Application for a non-material amendment following a grant of planning permission.

Number	28
Suffix	
Property name	
Address line 1	Rothermere Close
Address line 2	Up Hatherley
Address line 3	
Town/city	Cheltenham
Postcode	GL51 3UU

Demolition of existing conservatory and erection of single storey rear extension

Change the colour of the 3 Roof lanterns from White on the outside to Grey.

PROJECT EMAIL ADDRESS: andrew@chappellsmithltd.co.uk
PROJECT: 28 Rothermere Close
Cheltenham
TITLE: Proposed South East and South West Elevations
SCALE @ A3: 1:100
PROJECT NO: 20-357
DRAWING NO: 0005
REV: A

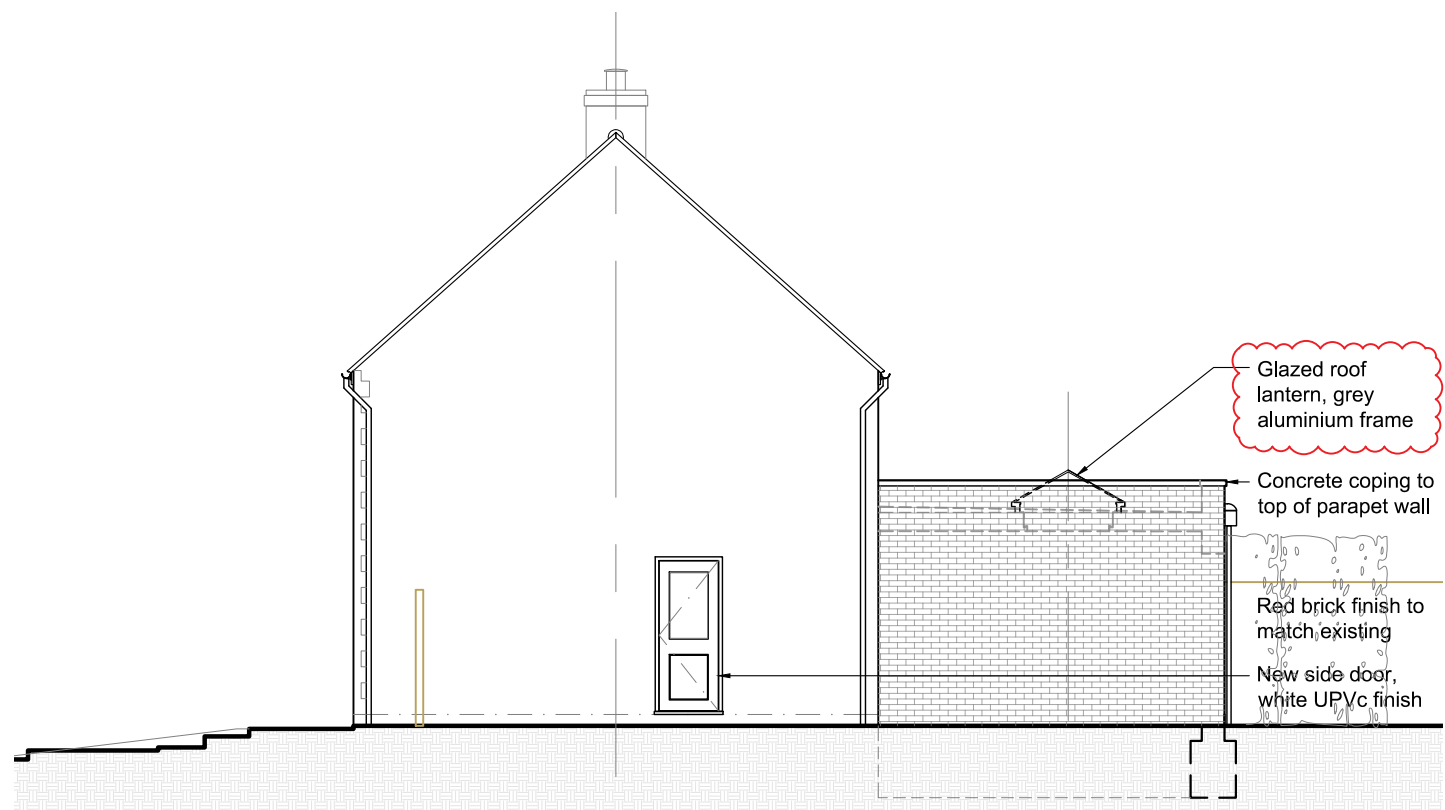
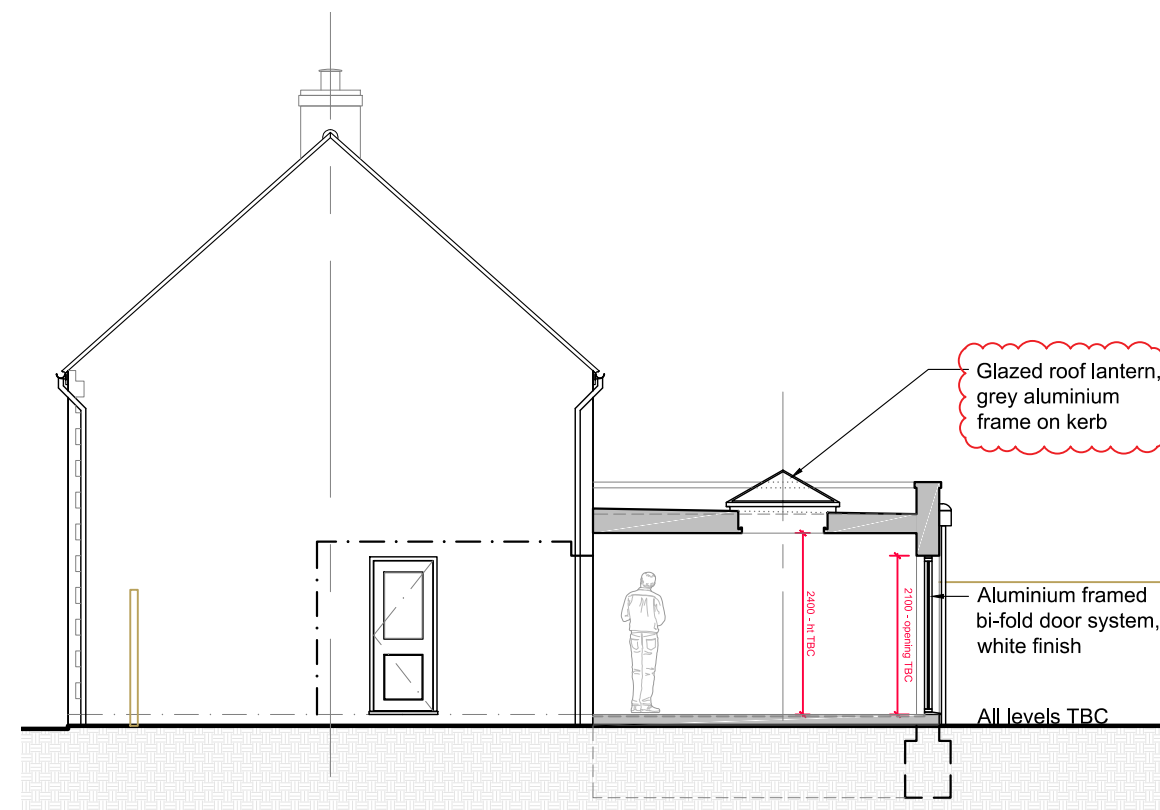
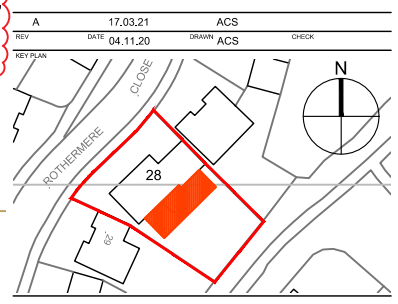
So that it does not appear dirty from outside with time, so needing less cleaning. Also colour will match the concrete coving on the extension roof.
